Submissions and Amendment Report

SSD 9835 – Sydney Football Stadium Stage 2

Modification 7 – Precinct Village and Car Park

Submitted to NSW Department of Planning,
Industry and Environment

DRAWING NO.	REVISION
LA-101	3

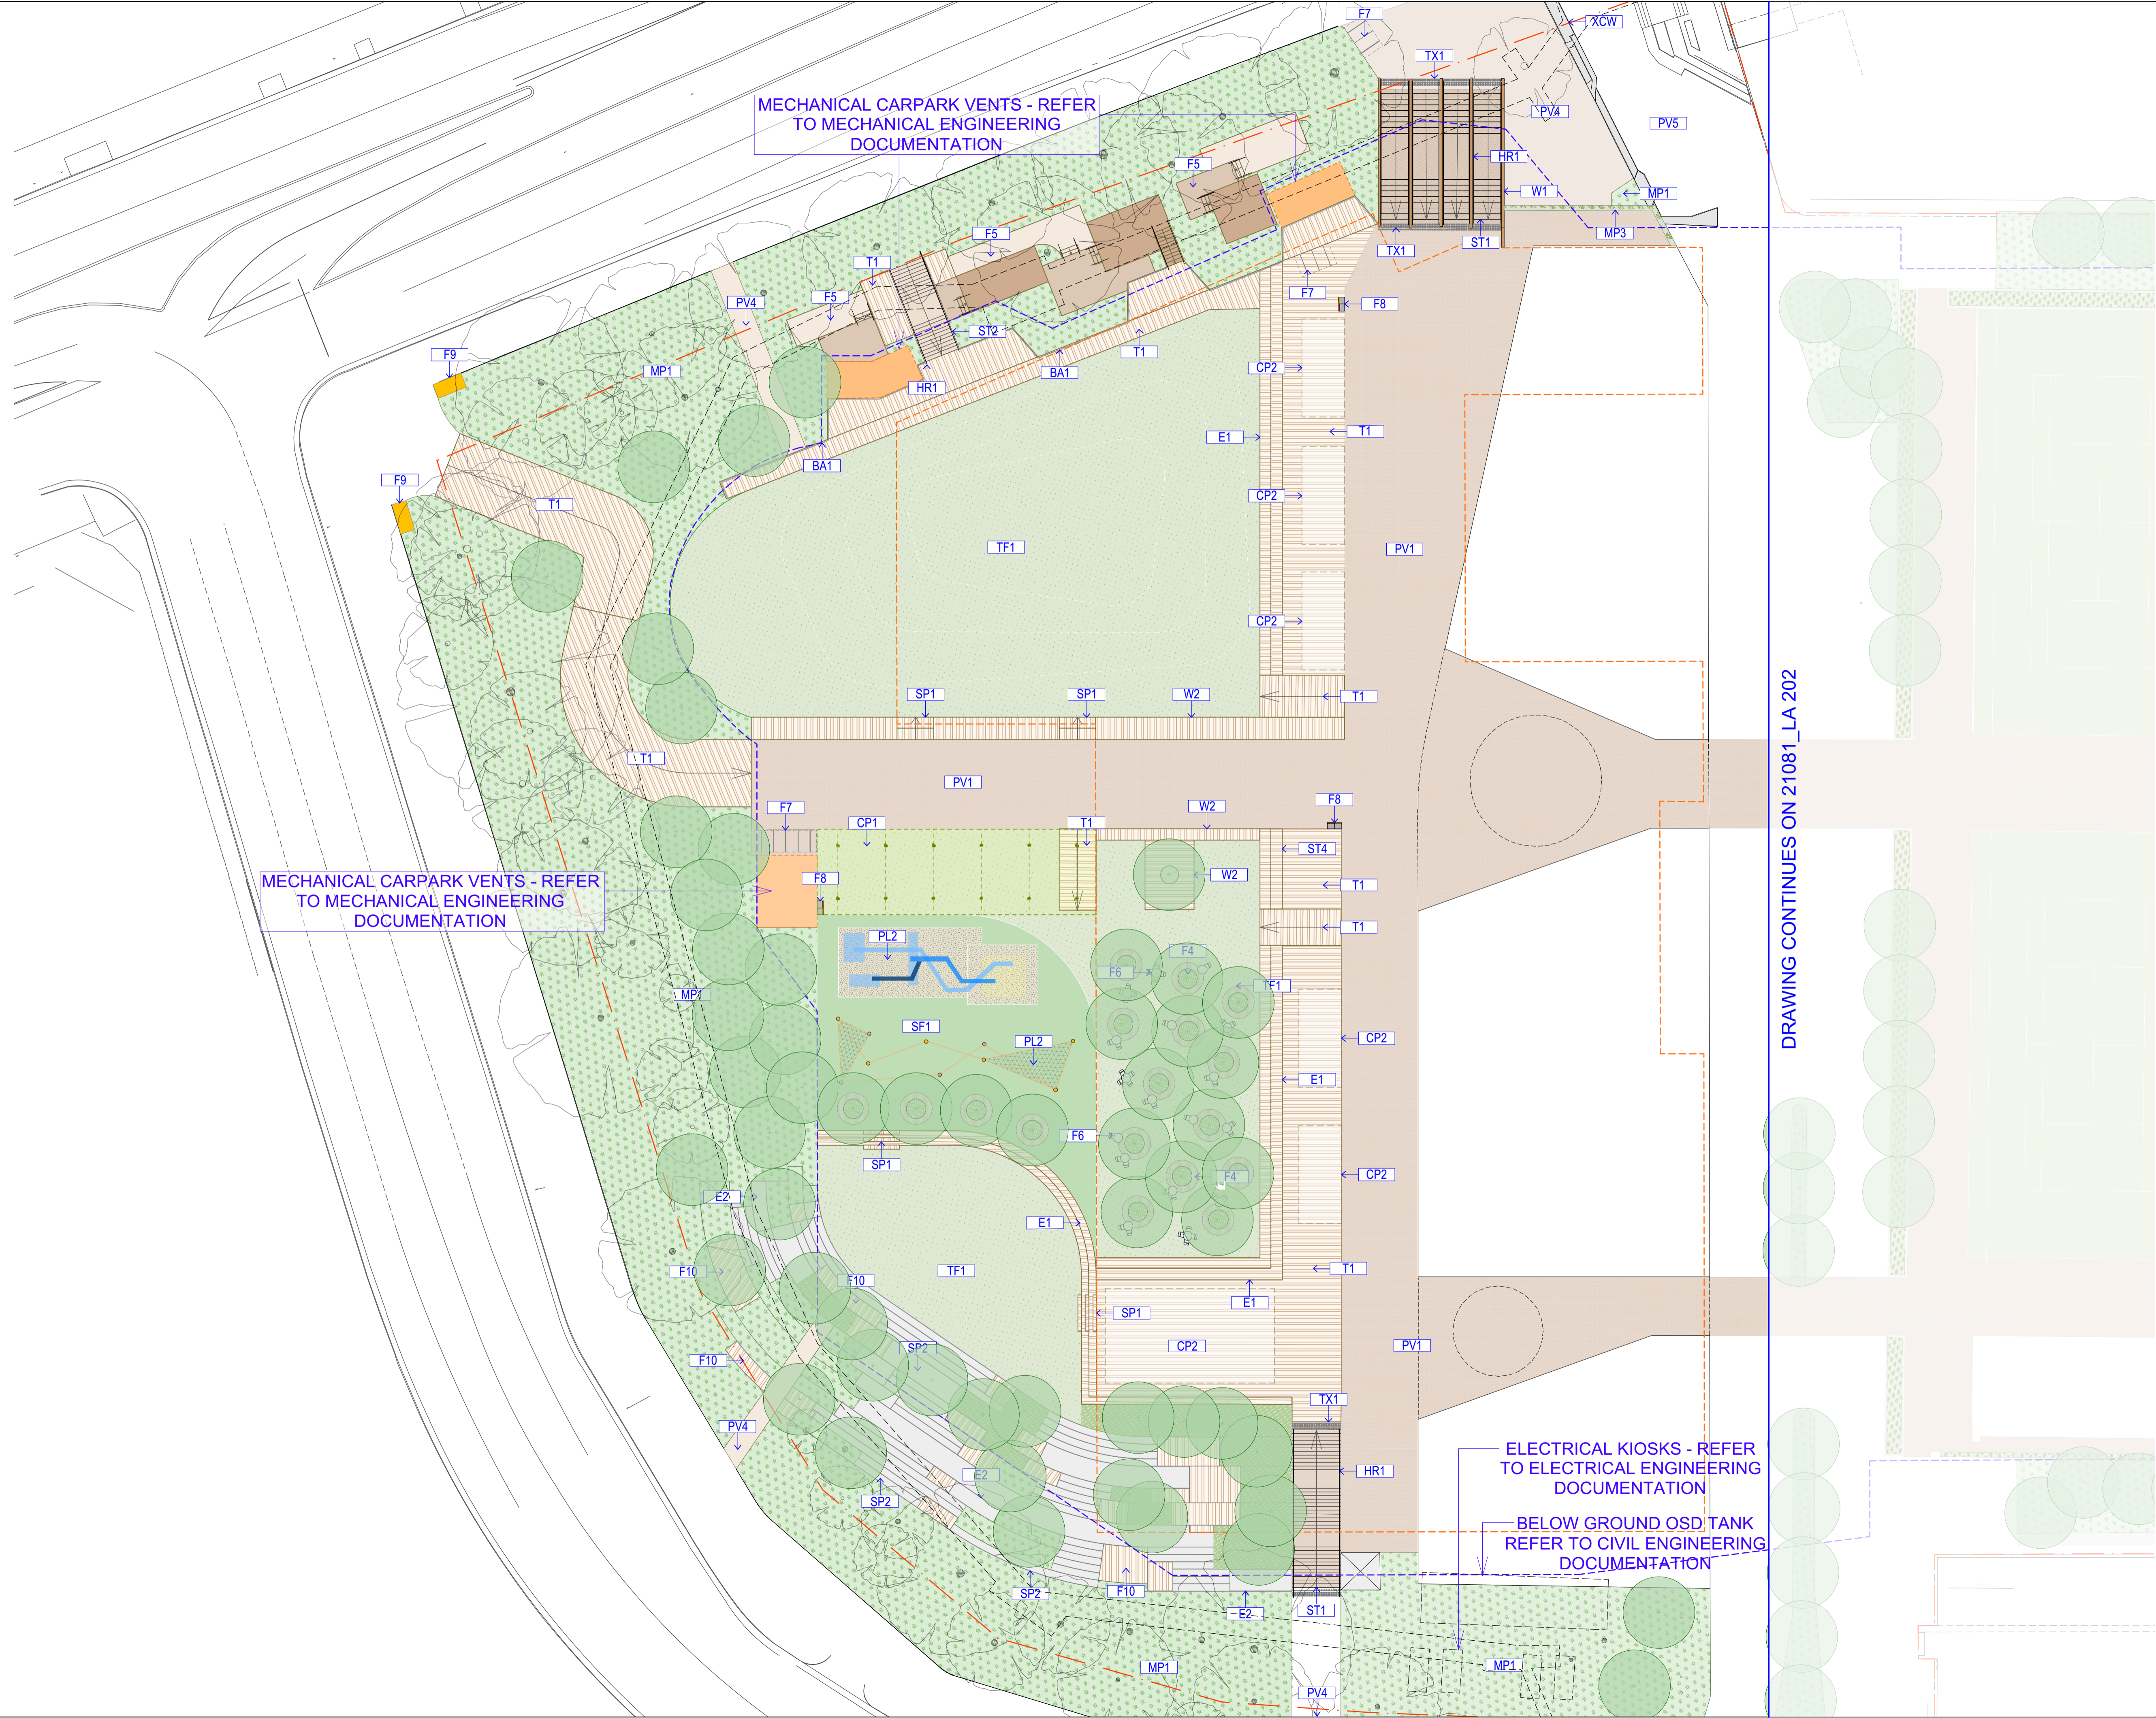
EES notes that the proposed modifications will result in the removal of 39 additional trees, which may constitute an increase in biodiversity impacts.

EES recommends that a consideration of the ecological significance, including habitat value, of all the trees identified for removal be conducted to support any decision on whether an increase in biodiversity impacts, as defined by the BC Act, is likely to occur thereby requiring the preparation of a BDAR.

As the consent authority, and pursuant to Section 7.17(2), the DPIE is required to consider whether the proposed modification will result in biodiversity impacts. The Biodiversity Development Assessment Report (BDAR) prepared and approved for the Stage 1 Concept Plan (SSD 9249) (Jacobs, May 2018) provided a comprehensive assessment of the SFS project footprint, including the land the subject of this Modification Application. The BDAR concluded:

The BDAR's impact assessment importantly concluded that while there is some native vegetation that has been planted on the land to which the Modification Application applies, the native vegetation is not naturally occurring and cannot be assigned to a Plant Community Type (PCT) or other vegetation zones as identified in the OEH BioNet Vegetation Classification. As a result, a vegetation integrity score cannot be determined in accordance with Biodiversity Assessment Methodology as there are no PCTs that will be impacted. The BDAR also identified that there are no threatened ecological communities located in or directly adjacent to the site, nor any indirect impacts on native vegetation or habitat resulting from the project on site. The construction and operation of the project is restricted to a discreet area and there are no adjoining areas of native vegetation beyond the development site that would be impacted.
